**From:** Hunyadi - DNR, John  
**Sent:** Tuesday, October 08, 2019 1:06 PM  
**To:** Charles Cothern  
**Cc:** Cothern, Charles; Durham, Charlene  
**Subject:** Re: The Gardens at North Carefree Detention Pond Breach Analysis

# Memorandum

Date: October 3, 2019

Subject: The Gardens at North Carefree Detention Pond  
Embankment Hazard Classification

V:\5287\6\active\187608744-Mule Deer\CAD\Sheets\Construction Drawings\25 - South Pond.dwg
2020/01/08 1:42 PM By: Pearce, Taylor

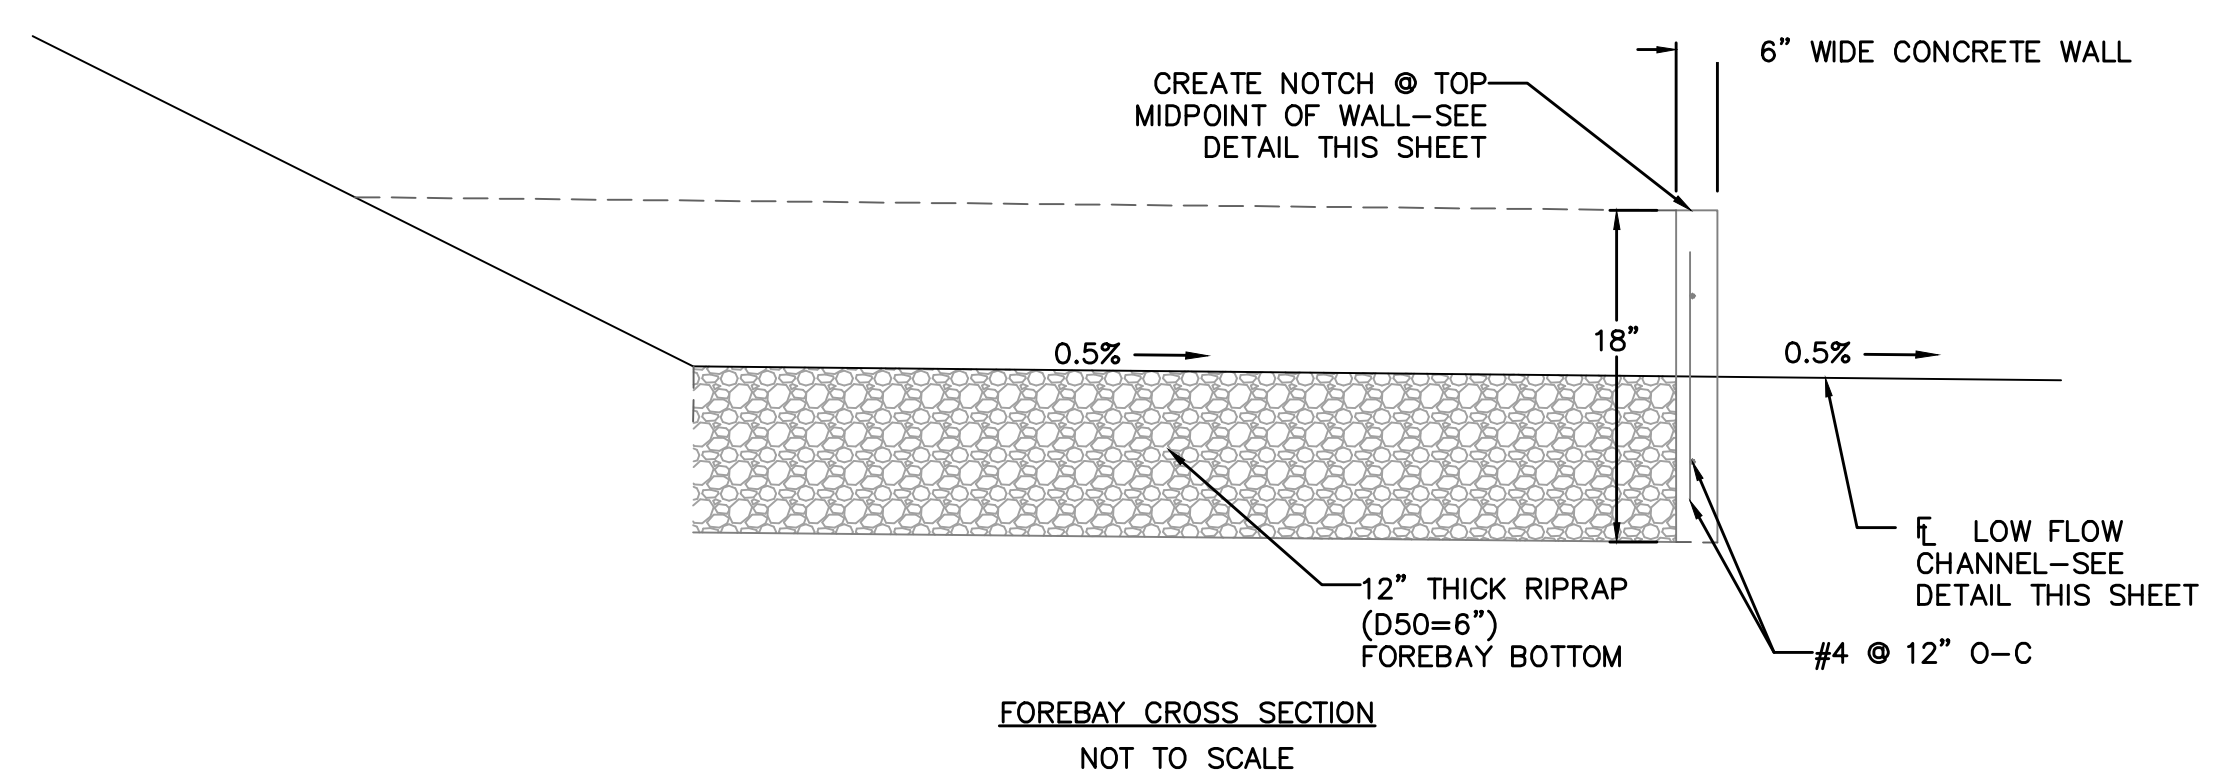
Thank you for the memorandum and analysis. I am in agreement with your conclusions regarding the hazard classification of these structures and will look forward to the NOI forms submitted to our office when you get to that point.
